Submission No.			098	
Organisation Name or Name of Submitter			Frank McDonald (6 The Cedar Glensavage Avoca Road, Blackrock)	
Item No.	Section Ref.	Page No.	Observation Statement	TII Response
RE: Railway Order application for Metrolink project (ref 314724)				
1		3	In reality, however, it is a classic example of the absence of joined-up thinking on transport in Dublin — a stand-alone project that doesn't make sense in its own terms and would need to be extended southwards in order to do so. An Bord Pleanála is, therefore, in the invidious position of being asked to make a decision on part of a much larger project without having any idea of where the rest of it would go.	As outlined in EIAR Chapter 03 (Background to the MetroLink Project), three major public transport projects proposed under the Transport Strategy for the GDA 2016-2035 (NTA, 2016), namely MetroLink, BusConnects and DART+ have been developed as independent standalone projects. These continue to be supported by the Transport Strategy for the GDA 2022-2042. However, these projects (together with the existing transport network and other public transport projects) are designed to provide a fully integrated transport netw

Drawing Title	METROLINK - STRUCTURES O'CONNELL STREET STATION PROPOSED STREET LEVEL DESIGN	Drawing Status	S0
Drawing N°	ML1-JAI-SRD-ROUT_XX-DR-Y-02071	Plan Drawing N°	ML-ST 305 F-G1
Scales Original Size A1	1:250	Sheet	1 of 7

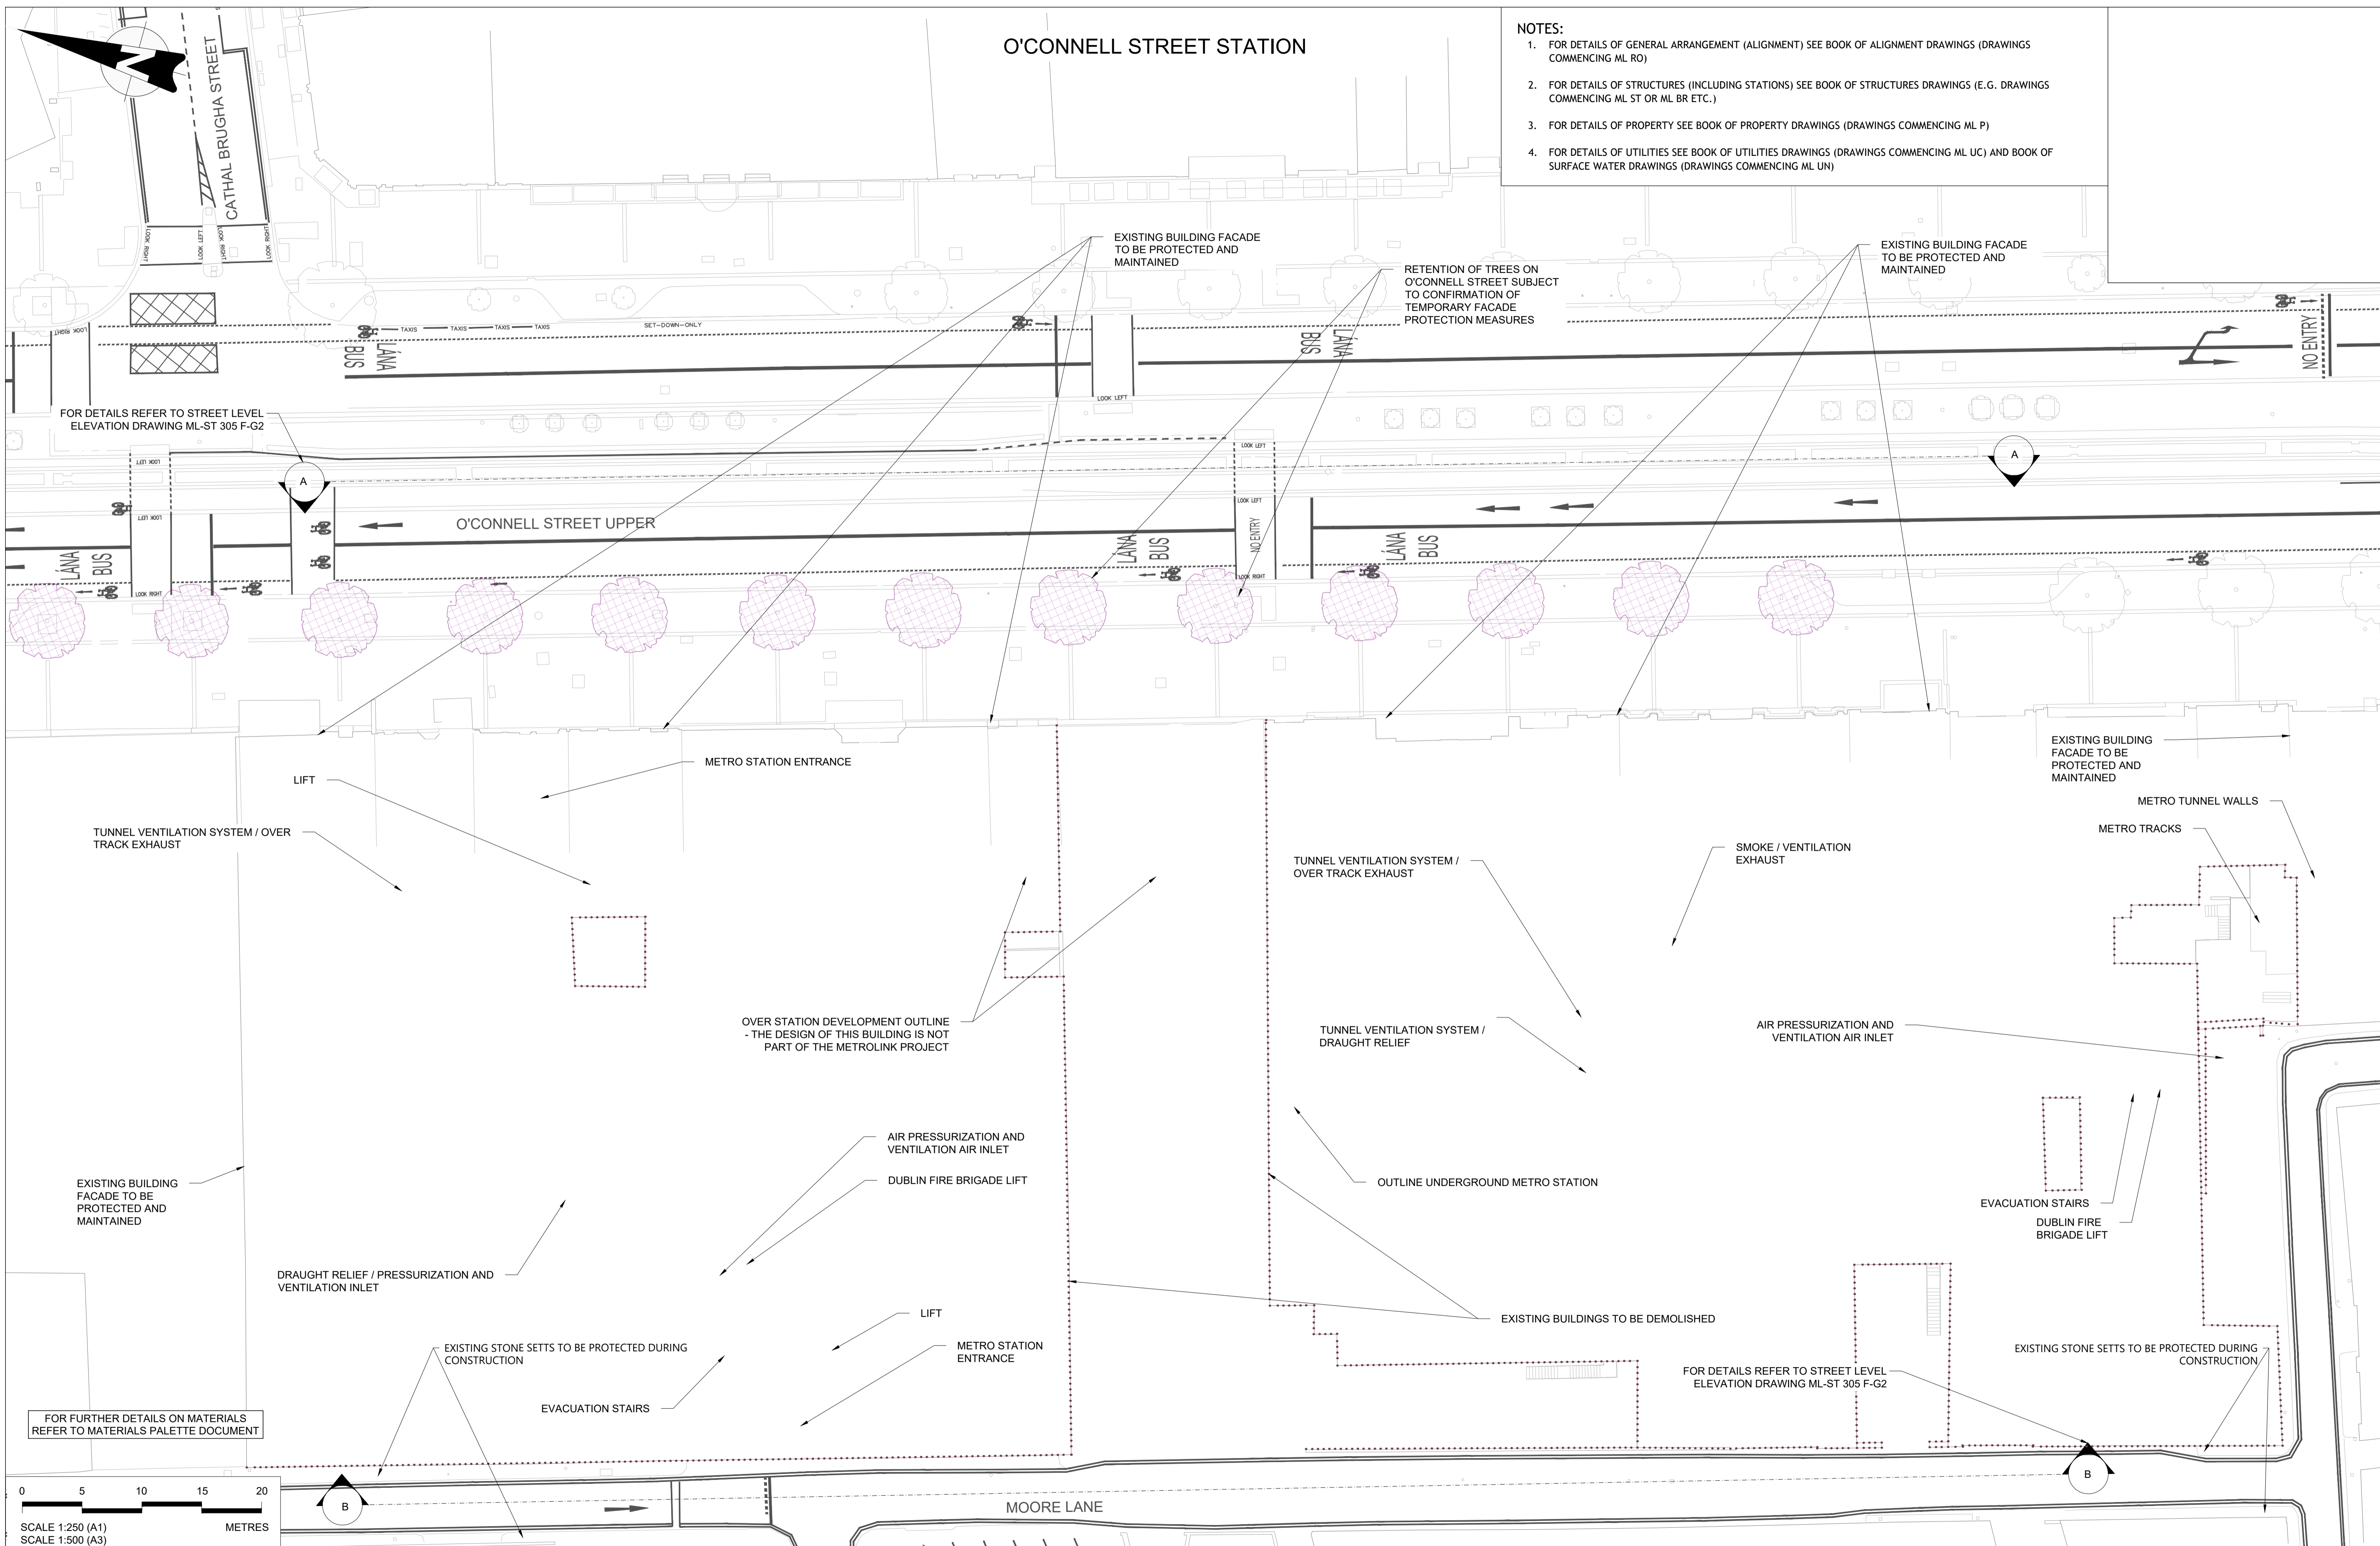
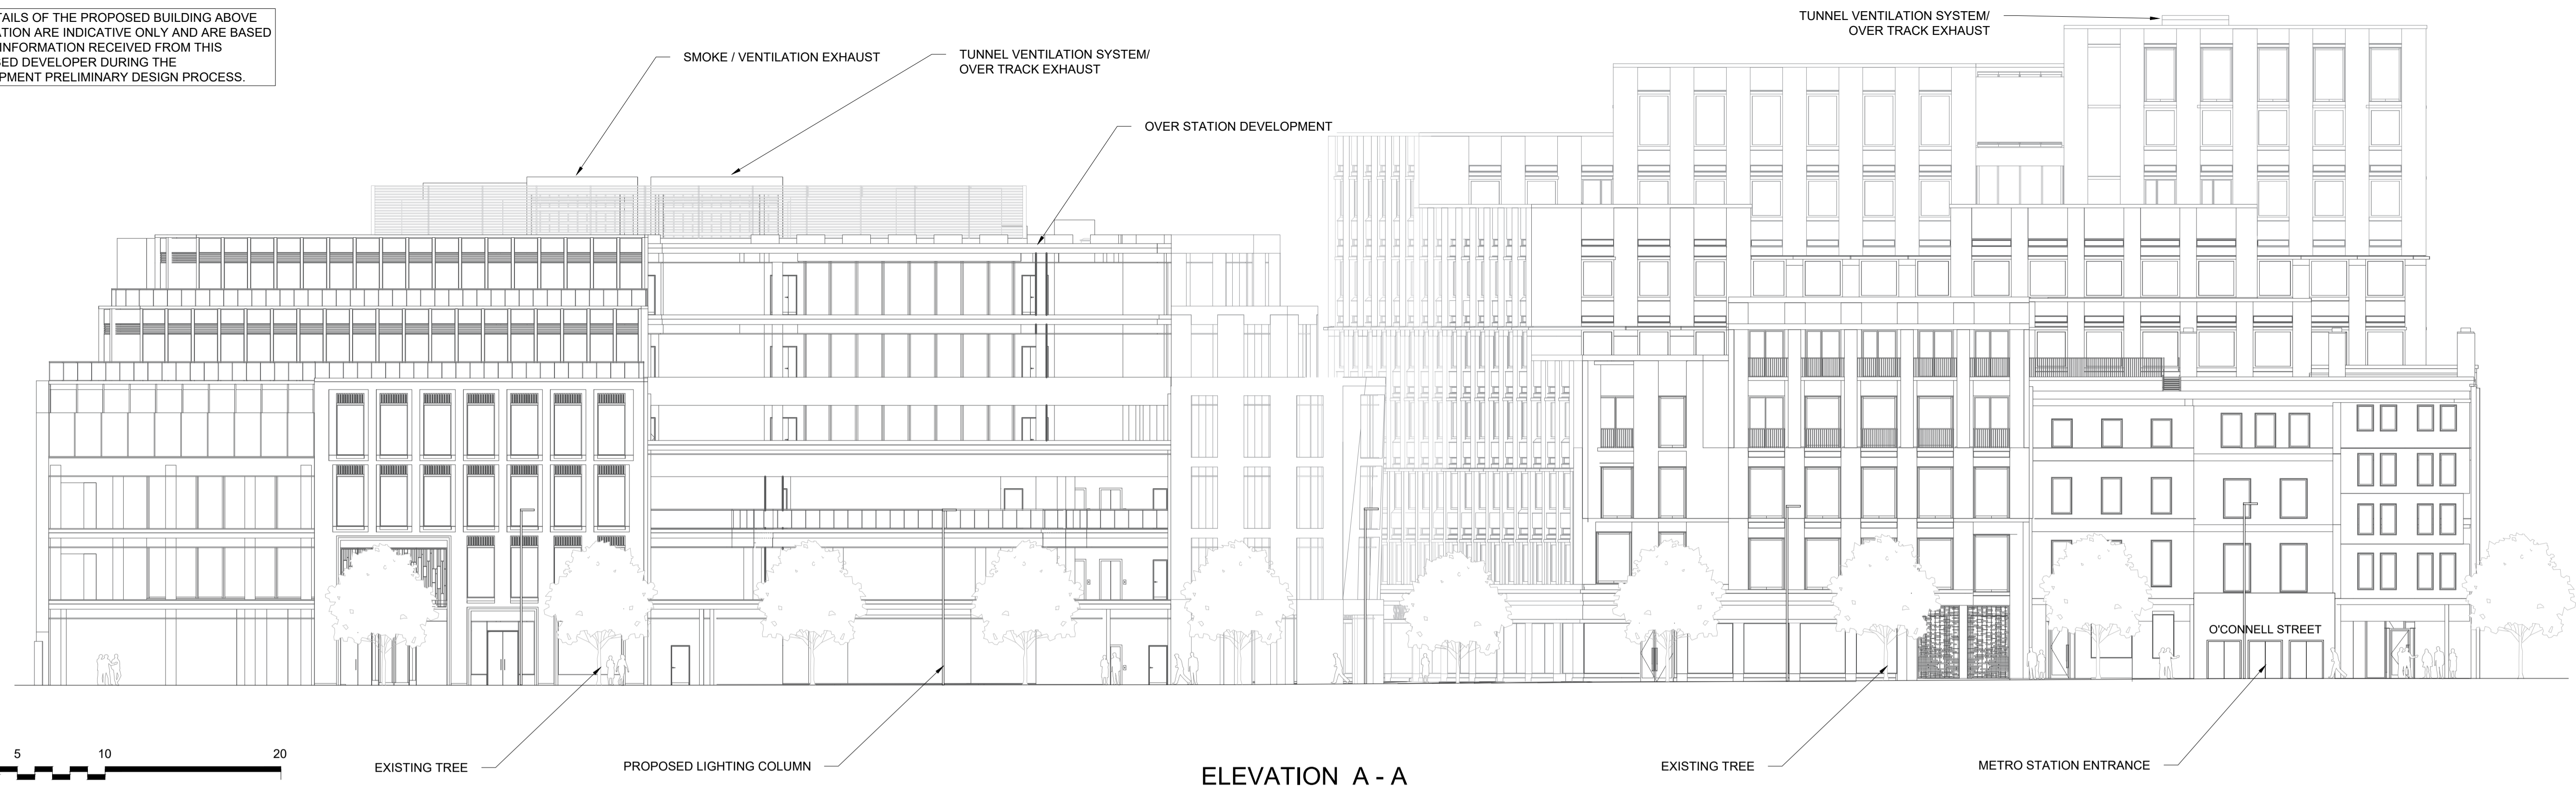
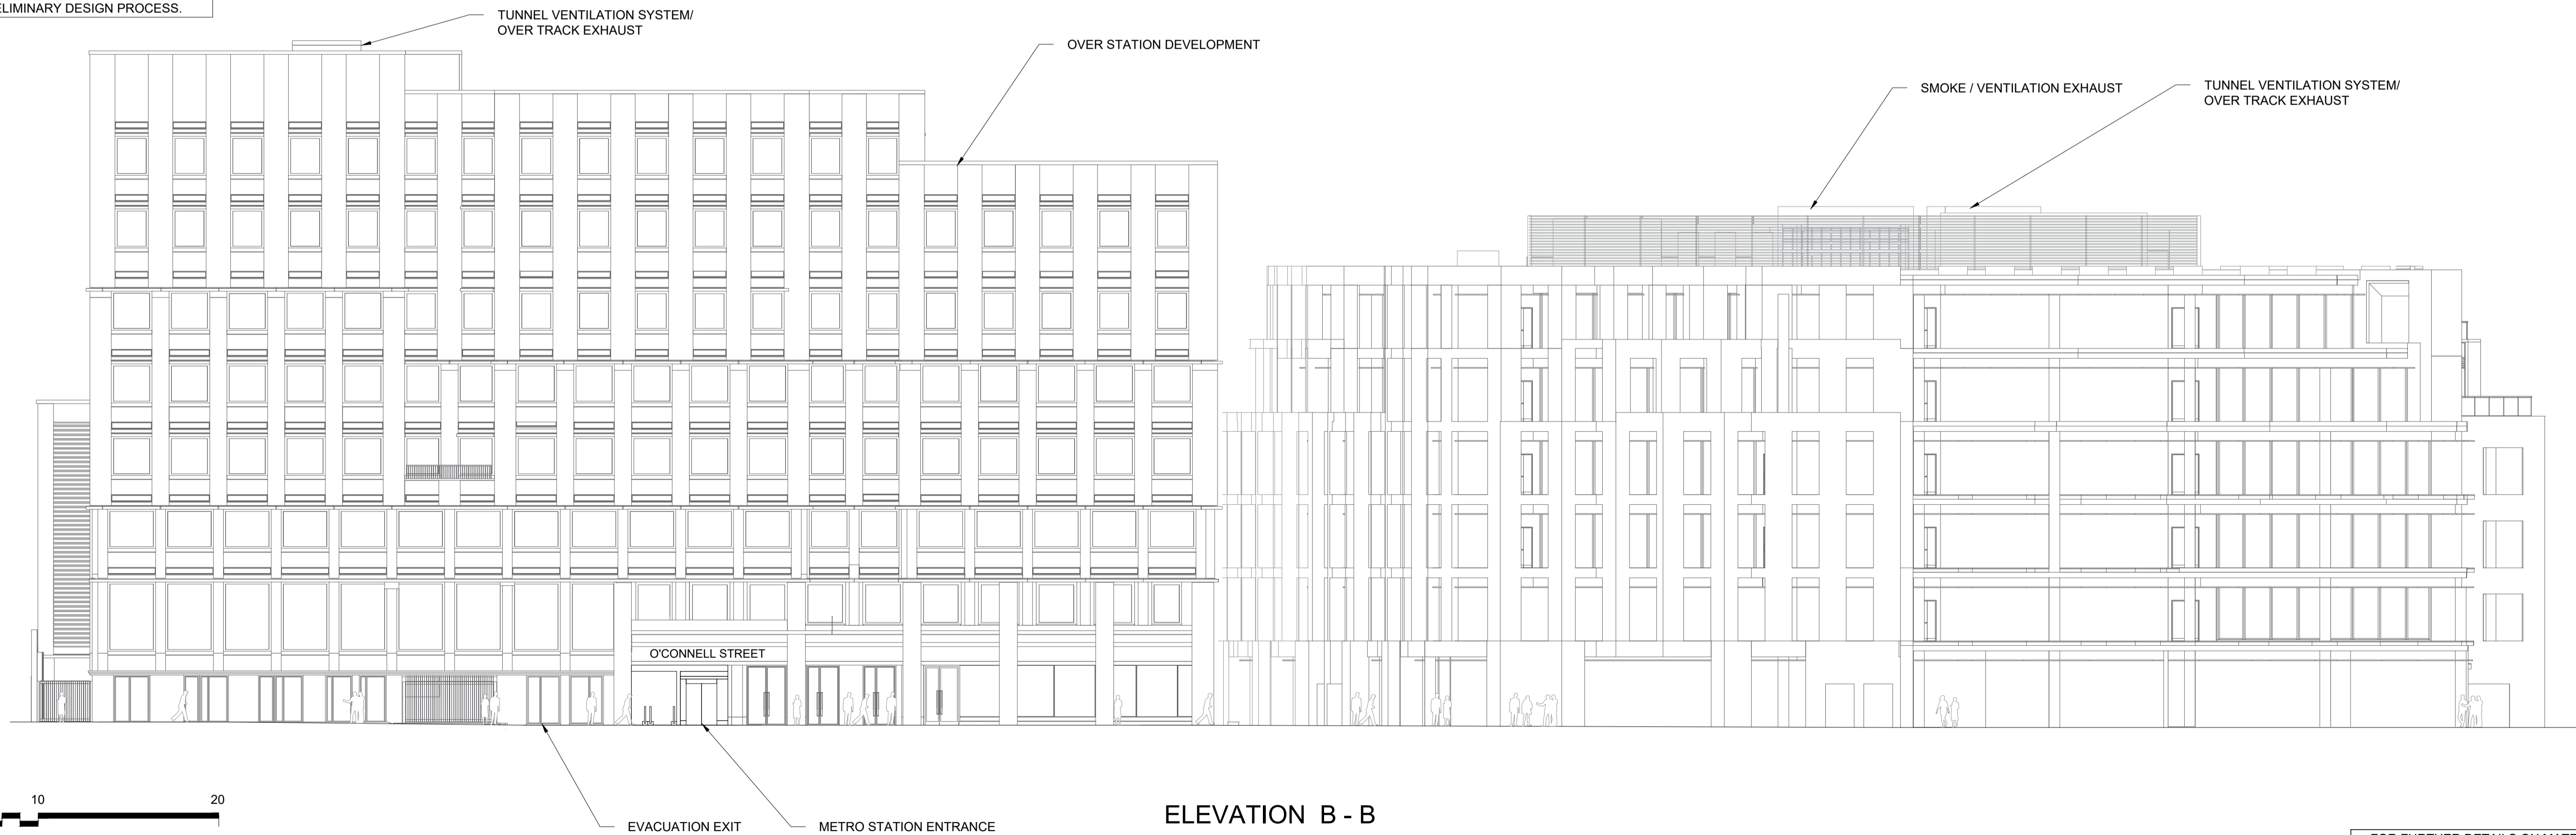
11		7	<p>The most tragic loss would be the former Carlton cinema, dating from 1938, which was one of the anchors of O’Connell Street for decades until its closure in 1994. With seating for 2,000 in its original format before it was subdivided into three cinemas in 1976, the entire volume of the Art Deco cinema still survives, including a significant amount of its original fabric.</p> <p>More than 20 years ago, the Carlton was proposed as a location for the National Conference Centre; indeed, its name was appropriated to refer to the development site even then being assembled by forerunners of Hammerson pic as the “Carlton site". It would be ideal for conversion into a concert hall or music venue to enliven this stretch of O’Connell Street.</p>	<p>Unfortunately as identified in Chapter 26 of the EIAR, whilst, the impressive facade of the Carlton Cinema will be retained, other elements will be demolished. However the impacts at this site and the adjacent site have to be considered in the context of this building not being used since 1994 and the adjacent site being vacant since 1976. The retention of this facade will ensure that it does not continue to deteriorate due to dereliction. In addition, prior to the demolition of number 52-54 O’Connell Street Upper the building is to be recorded to English Heritage level 3. The recording of associated coal cellars to facilitate propping of the facades, the demolition and the propping of the facade are to be carried out in accordance with a method statement compiled by the PCA or by the appointed contractor’s conservation architect and approved by the PCA. Vibration and settlement monitoring equipment is to be installed in the retained façade and monitored to ensure that at no time do vibrations or settlement exceed given limits. The equipment is to be monitored and in the event of threshold limits being exceeded all work in the vicinity is to stop until the cause of the issue is identified and resolved.</p>

12		7	<p>Instead, as the EIAR notes, “the Carlton ... is to be demolished, except for the facade, as part of the works to construct O’Connell Station. The section to be demolished [the entire interior] is not part of the protected structure, though it is included in the NIAH. To facilitate the supports for the façade during construction, the cellars beneath the footway will be infilled with concrete ...</p> <p>Again, the predicted impact is rated as “very significant". As someone who remembers the cinema in its heyday as well as the Carlton Grill on the first floor, overlooking O’Connell Street, I sought to persuade Hammerson to retain and refurbish its Art Deco glory. They were also open to considering options for its future use, including the idea of turning it into a music venue.</p> <p>But that was before the alignment of MetroLink was altered so that, instead of excavating a station box in the middle of O’Connell Street as originally envisaged, it was now to be done behind propped-up façades along its west side. It is clear that the combined impact of MetroLink and Hammerson’s Dublin Central scheme will fundamentally change the character of the street.</p>	<p>Please refer to response item (11) in relation to the demolition associated with the construction of O’Connell Street Station.</p>
